Our Ref: LU/119/14/PL
Your Ref:

Town & Country Planning Act 1990 (as amended)
Town and Country Planning (Development Management Procedure) (England) Order 2010 (as amended)
Application for Planning Permission

Development Change of use from business (B1 Business) to 2 No flats (C3 Dwelling House).

Location 3 High Street Littlehampton

Drawing No. 14.01.03/5
Scale 1/50
Date 4/2014
Sheet Size A1

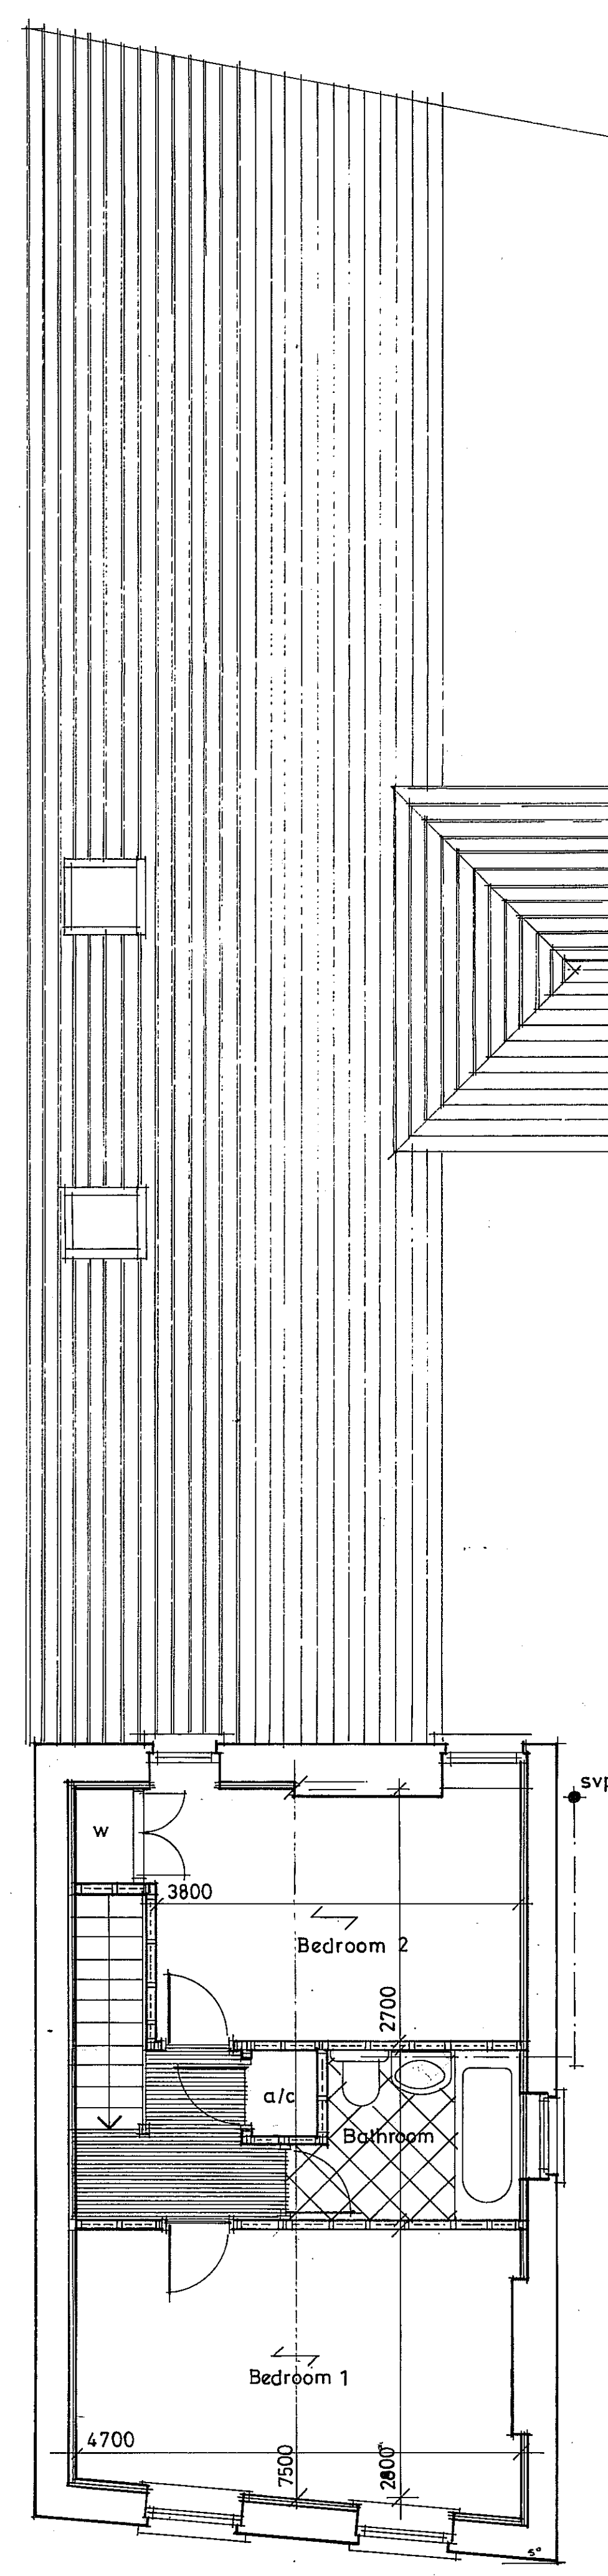
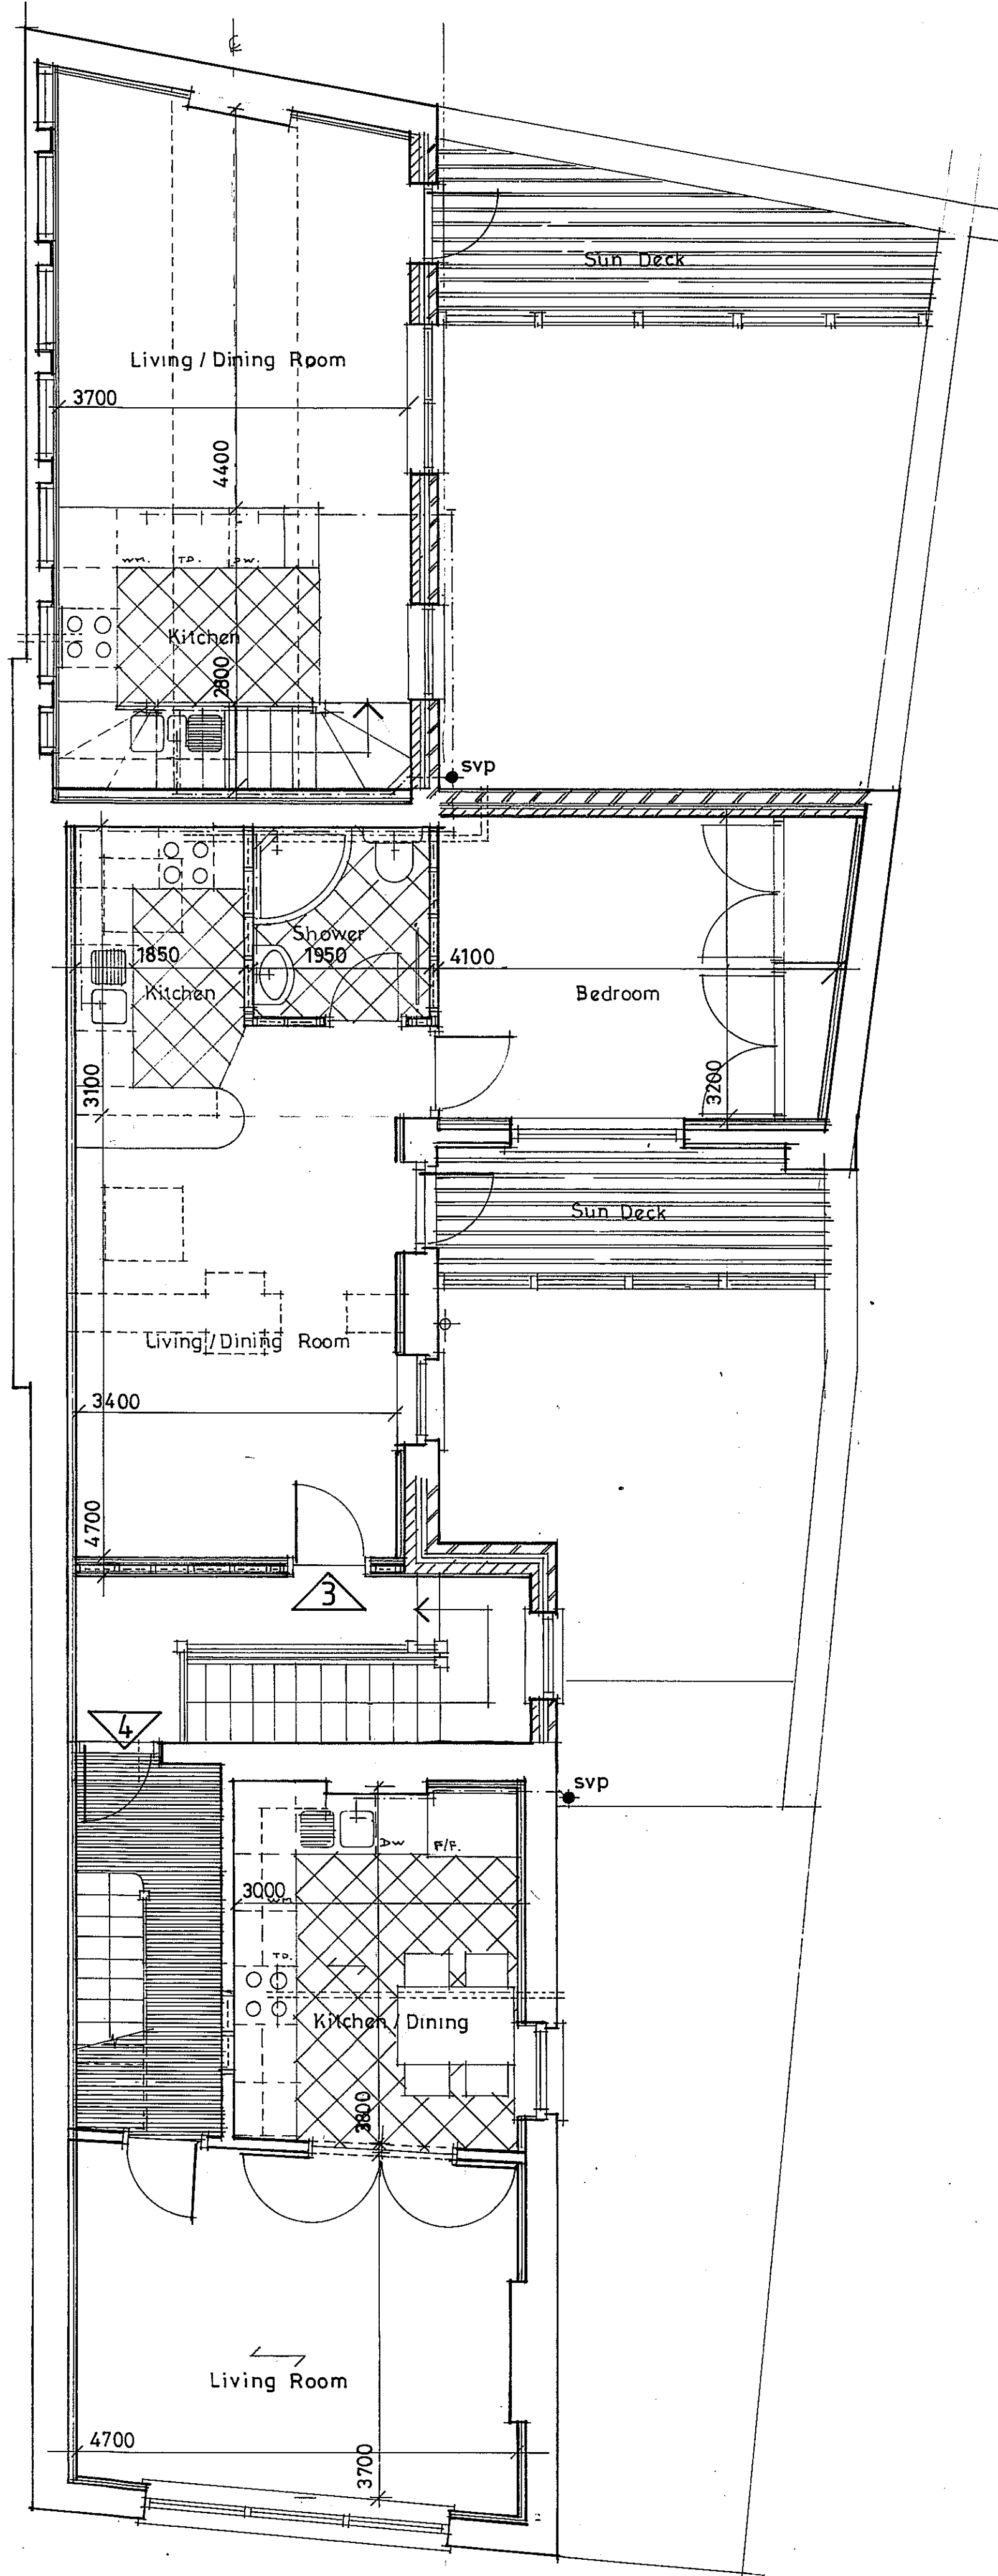
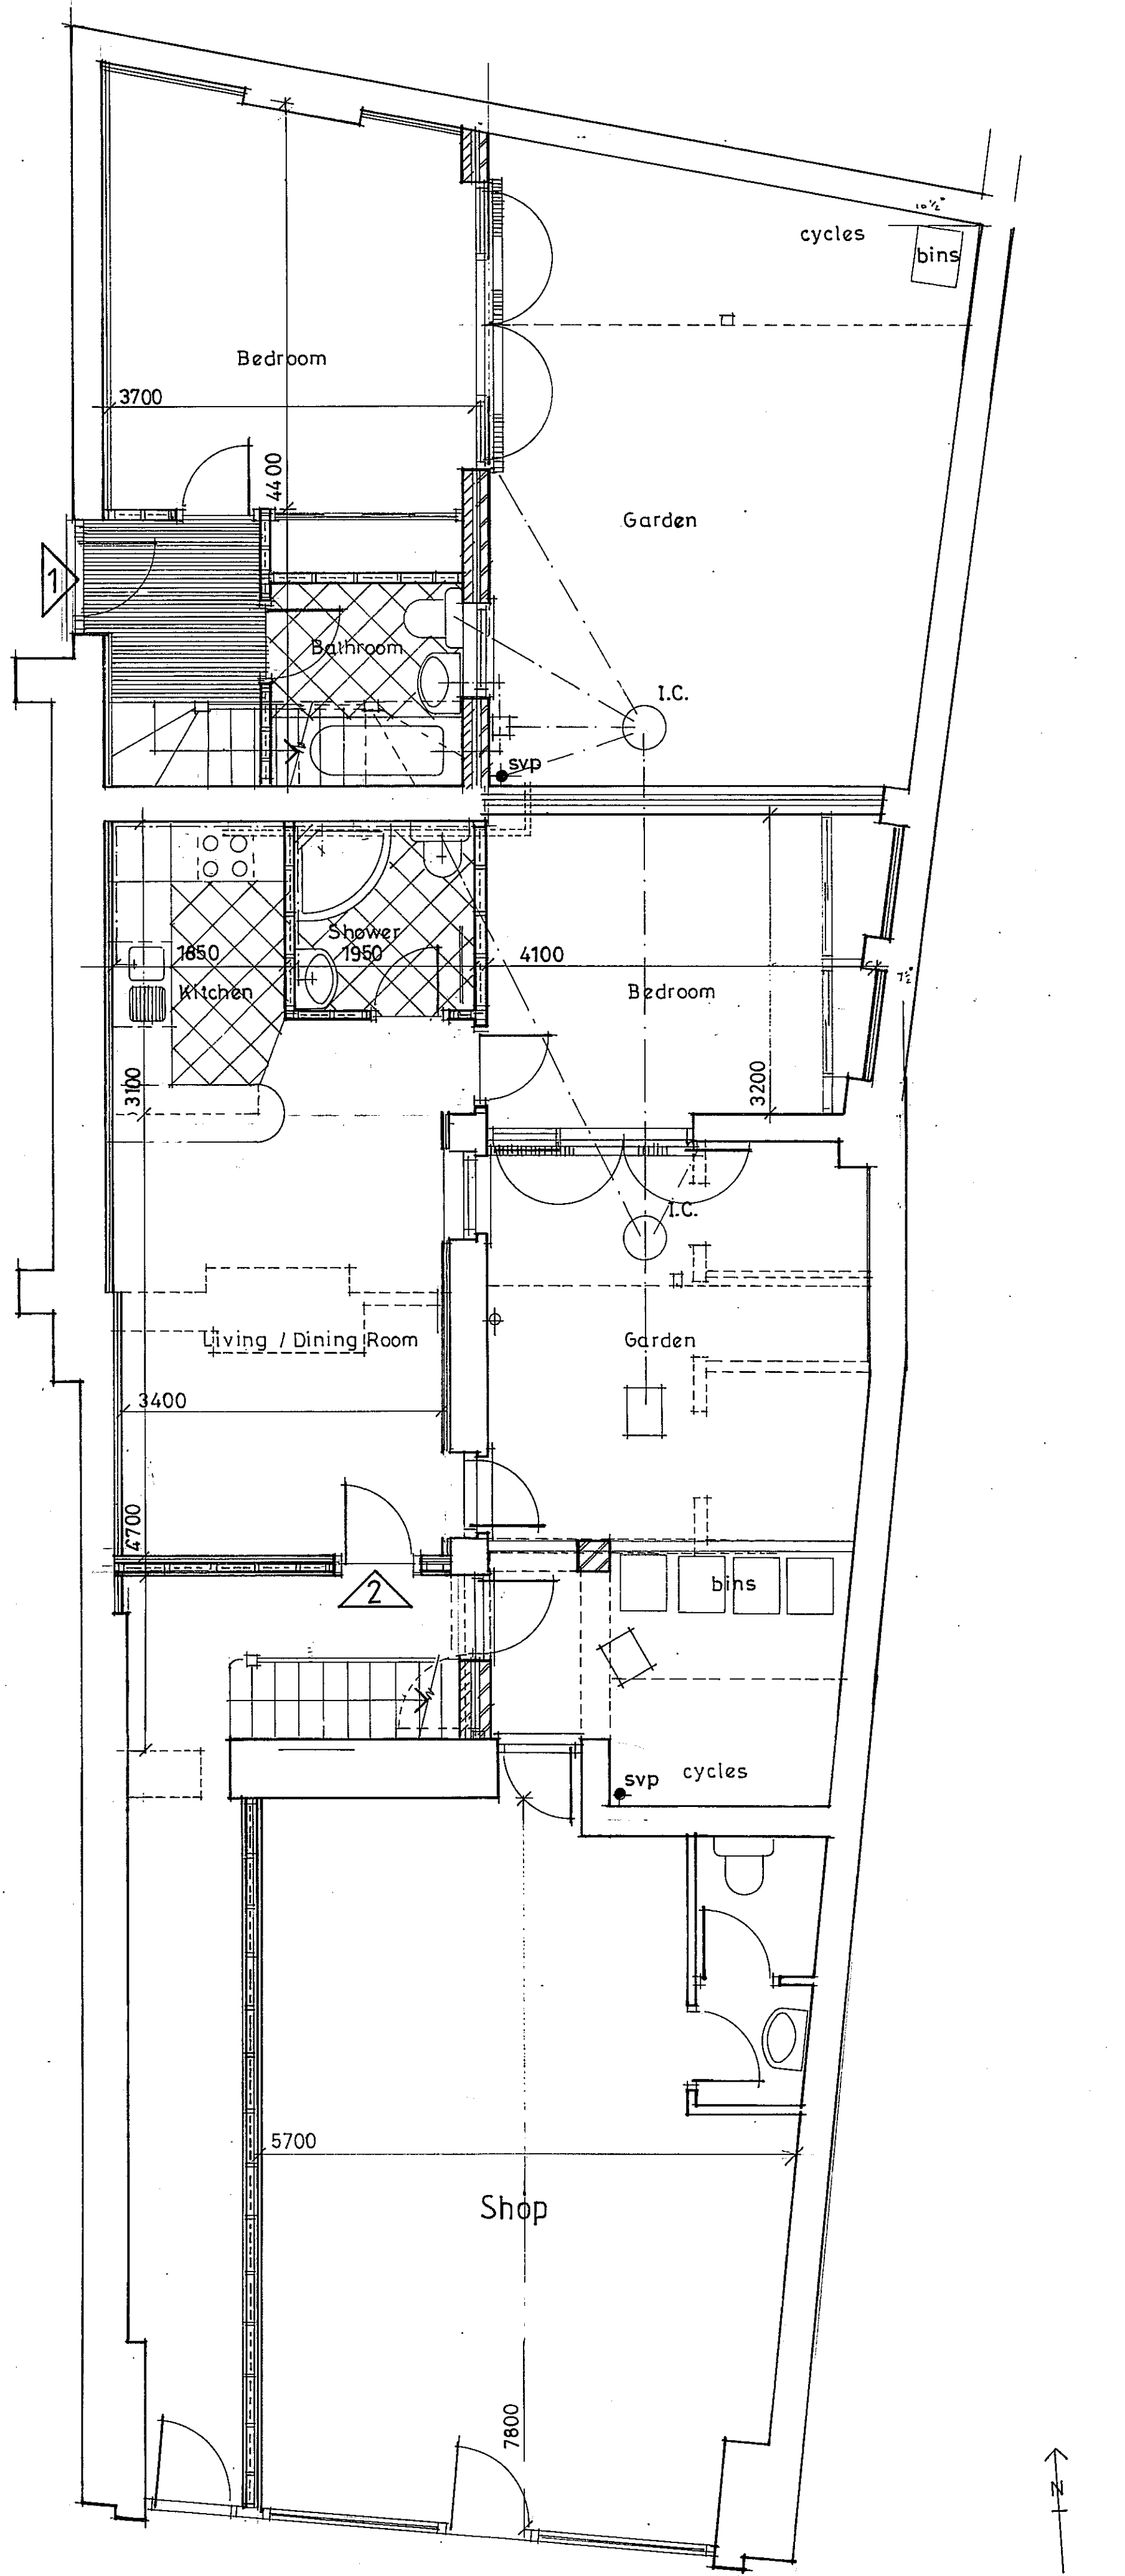
The proposed South elevation at first floor level does not accord with the proposed floor plan at first floor level. Please amend accordingly.

Please amend the plans and elevations to only show the B1 to C3 change of use. You may amend the plans, taking off what is not being applied for, or clearly indicate on the plans that only the change of use from B1 to C3 is being applied for.
